Our ref.: MP06\_0025 MOD 5

**Stage 1 Vincentia Town Centre, Vincentia (MP06\_0025 MOD 5)  
Response to Submissions**

## Attachment 1

— Swept Path of Vehicle Body
— Swept Path of Clearance to Vehicle Body

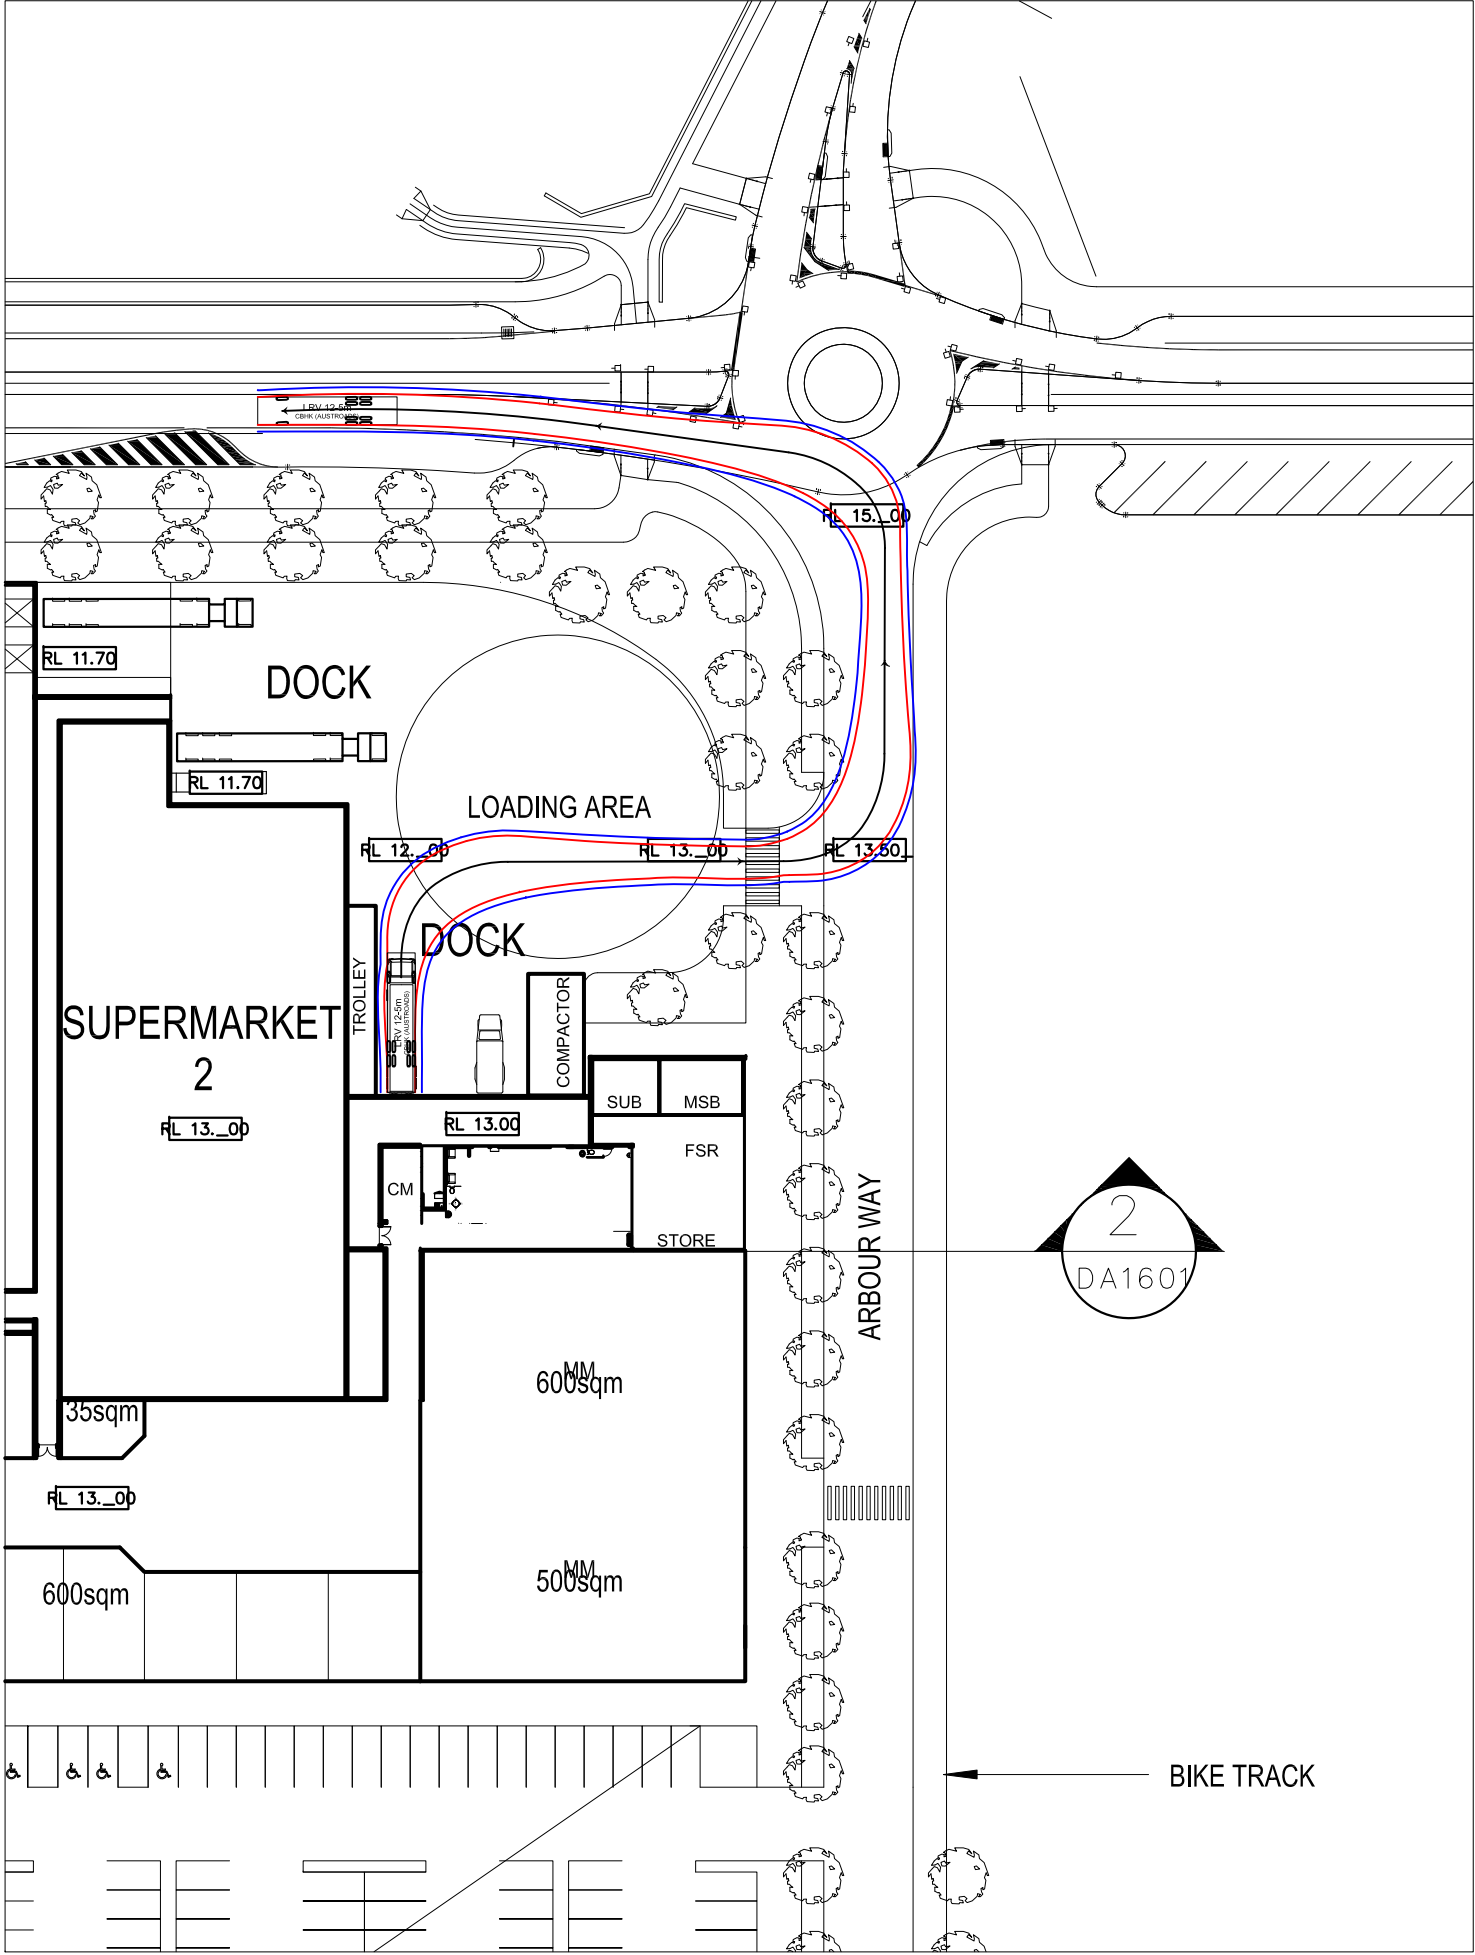
- The proposed use of Arbour Way as the main pedestrian spine into the centre, conflicts with the need to provide clear and unobstructed access to the loading dock and vehicular access to the car park. Consideration should be given to an alternate loading / unloading arrangement (including relocation options using the western road access off Moona Creek Road) to minimise conflicts with other vehicles / pedestrians.

- need for details of road reserve dimensions at the proposed roundabout at Halloran Road and MCR are required not encroaching outside the site;
- need for details on the usage / traffic patterns at western access to car park or from internal traffic flow / queuing for fuel and fast food outlets;
- need for construction timing of MCR prior to CC for Stage 1;
- further information on the opportunity to include a taxi call system within car park; and
- need for details of swept paths for Stage 2 to validate practical use of the loading docks.

1 ELEVATION
WEST ELEVATION - MOONA CREEK ROAD

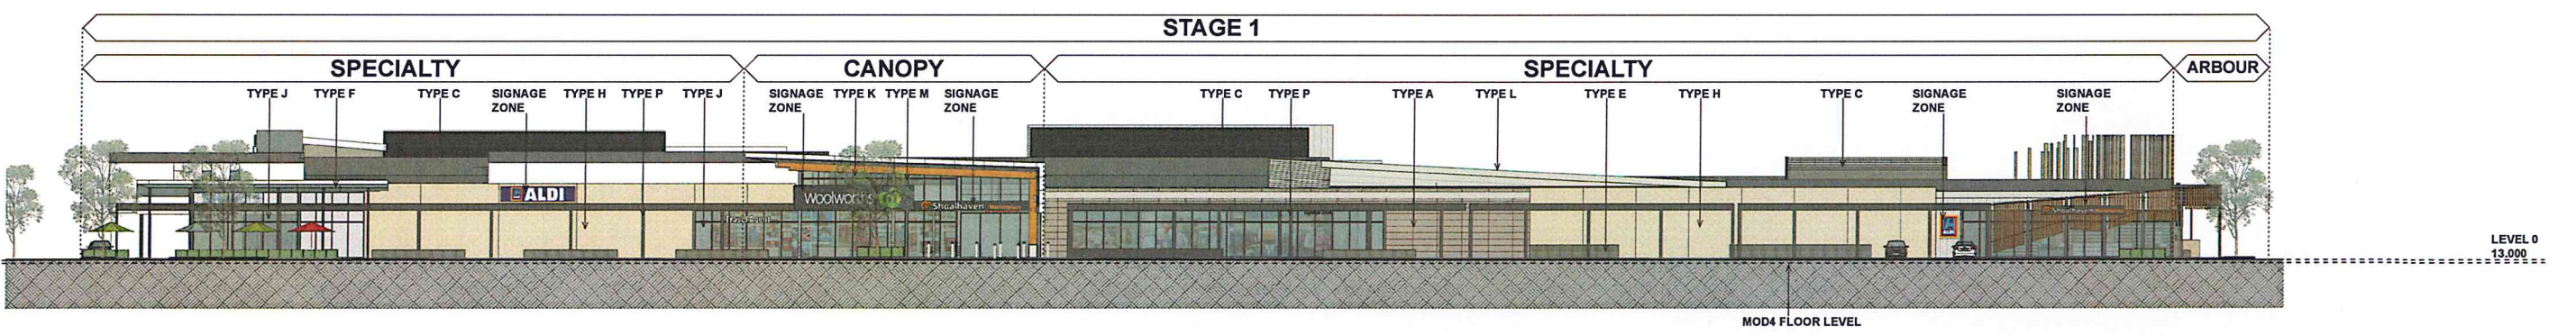
- the reorientation of the proposed building away from Moona Creek Road conflicts with the intention of the original approval to create a main street to the town centre.

- establishing a relationship of the buildings with the main street including existing development maximising activation of MCR;
- relocation of the loading dock away from a prominent corner which will result in conflict between delivery vehicles and pedestrian movements;

- a convenient entrance within the eastern elevation to the building to reduce travel distance and activate the street frontage; and
- establishing a relationship with surrounding commercial uses (such as medical centre opposite) and residential subdivision within which the site is located.

TEMPORARY REVEGETATED LANDSCAPE

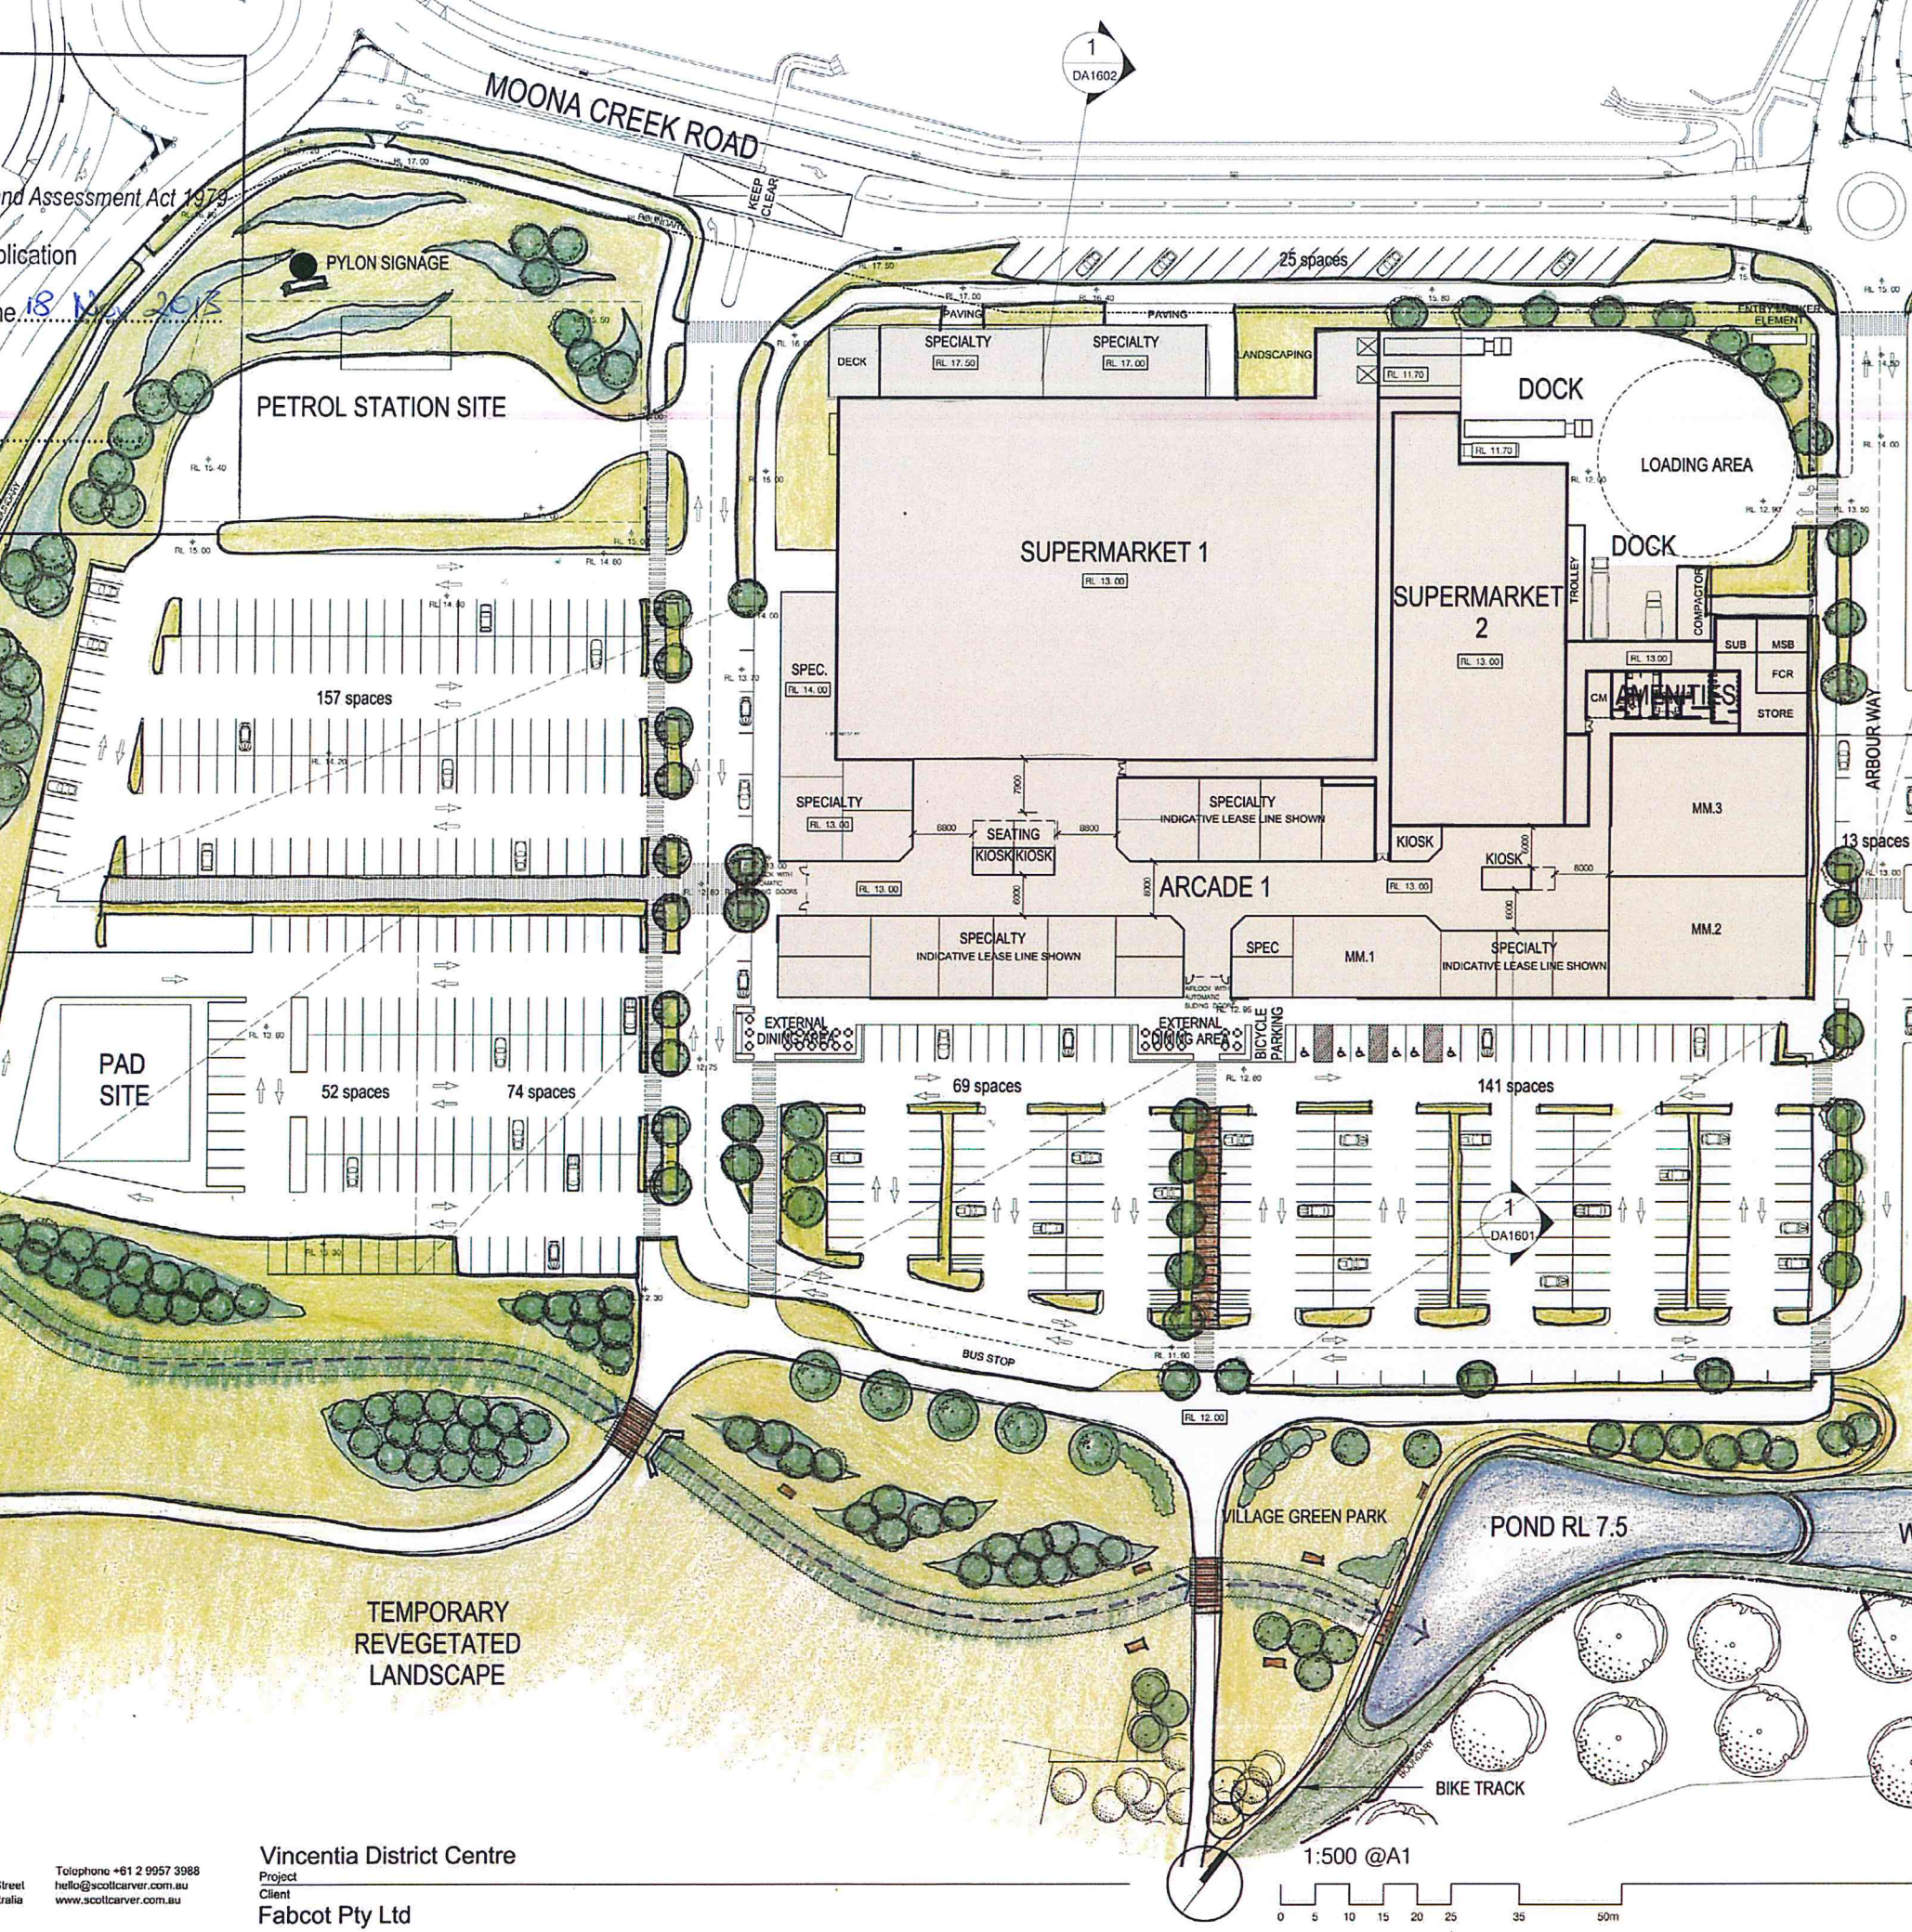
- Clarification is sought on a definition of 'temporary revegetated landscape', how this area will be vegetated and managed and incorporation into the Statement of Commitments.

- Details of the proposed landscaping and timing for the temporary vegetated landscape should be provided.
